## PLANNING CONSULTATION RESPONSE

<b>Application No</b>	2026/0102
<b>Proposal</b>	Erection of front and side boundary wall 1m to 1.5m in height (Retrospective).
<b>Address</b>	11 Hardwick Grove, Dodworth, Barnsley, S75 3SS
<b>Date of Consultation Reply</b>	31/03/2026
<b>Consultee</b>	Laura Downs Planning Enforcement Officer

Drawing Title **SITE PLANS**

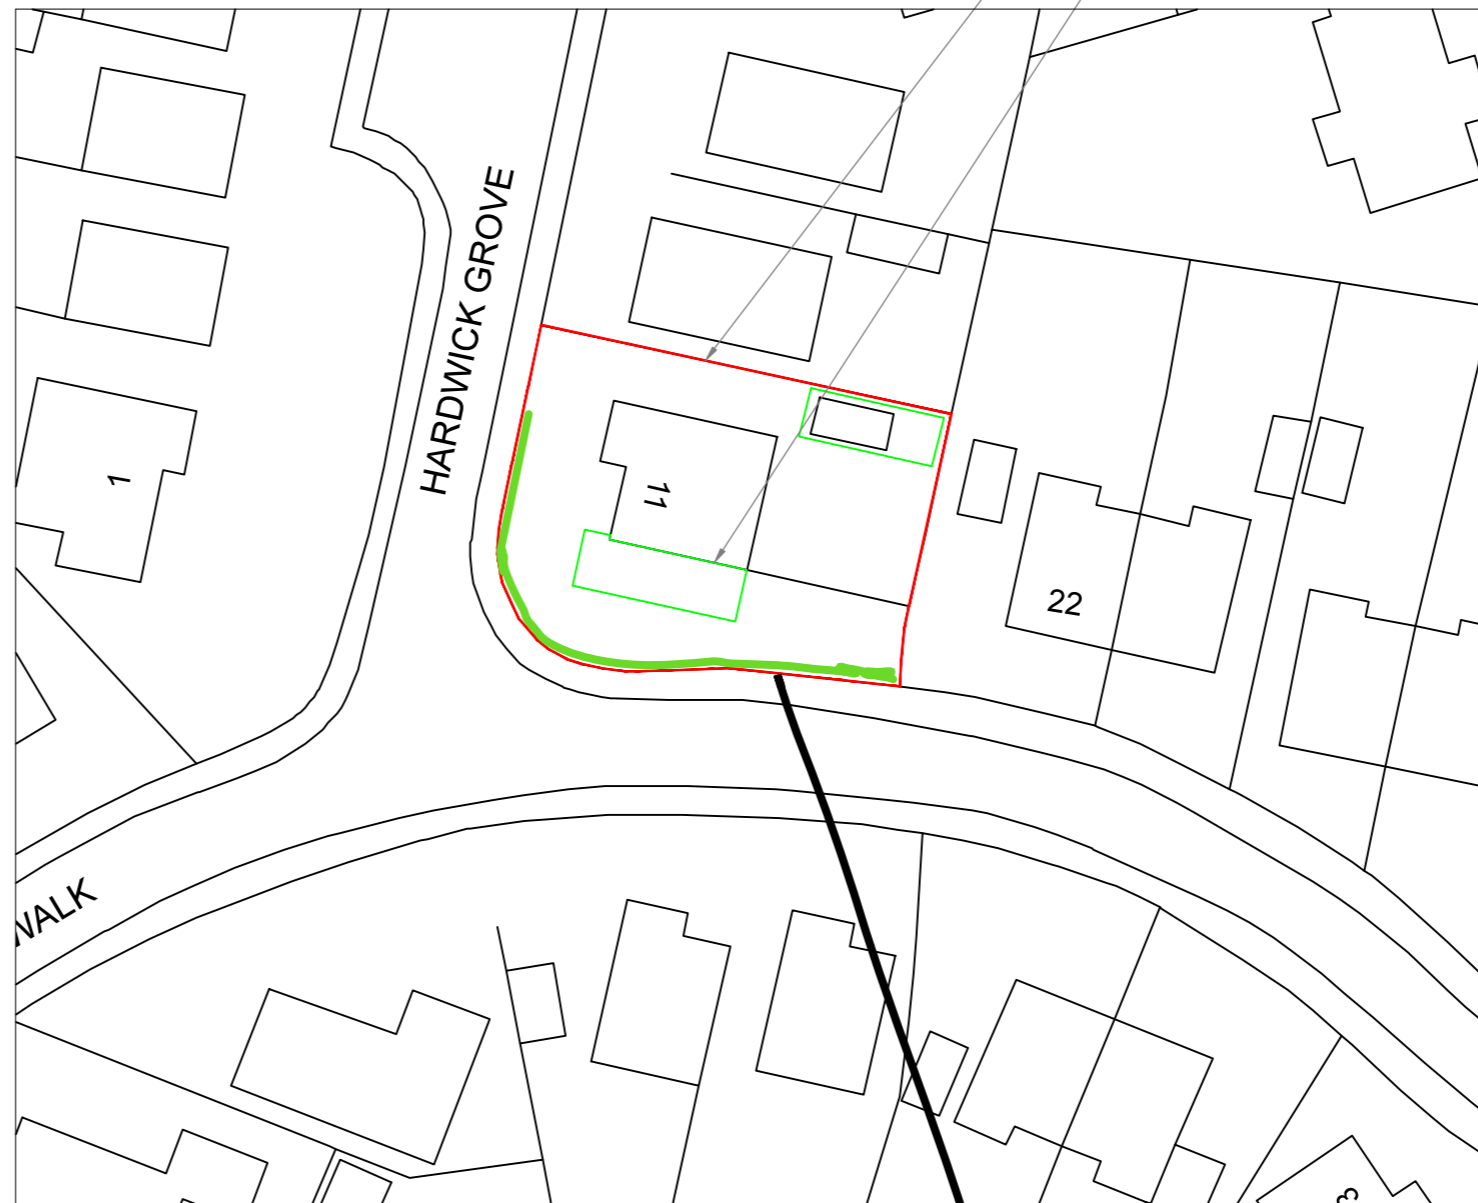
The development does not comply with the plans and particulars of application 2024/0426, which referenced a boundary wall to be constructed less than 1 metre high under permitted development rights. Complaints about the construction, location and appearance of the wall have been received which has resulted in the revised planning application being submitted for consideration. The wall, due to its height and location is largely out of character with the surrounding street scene which is characterised with open frontages, planting and vegetation and very low level wall boundary treatments.
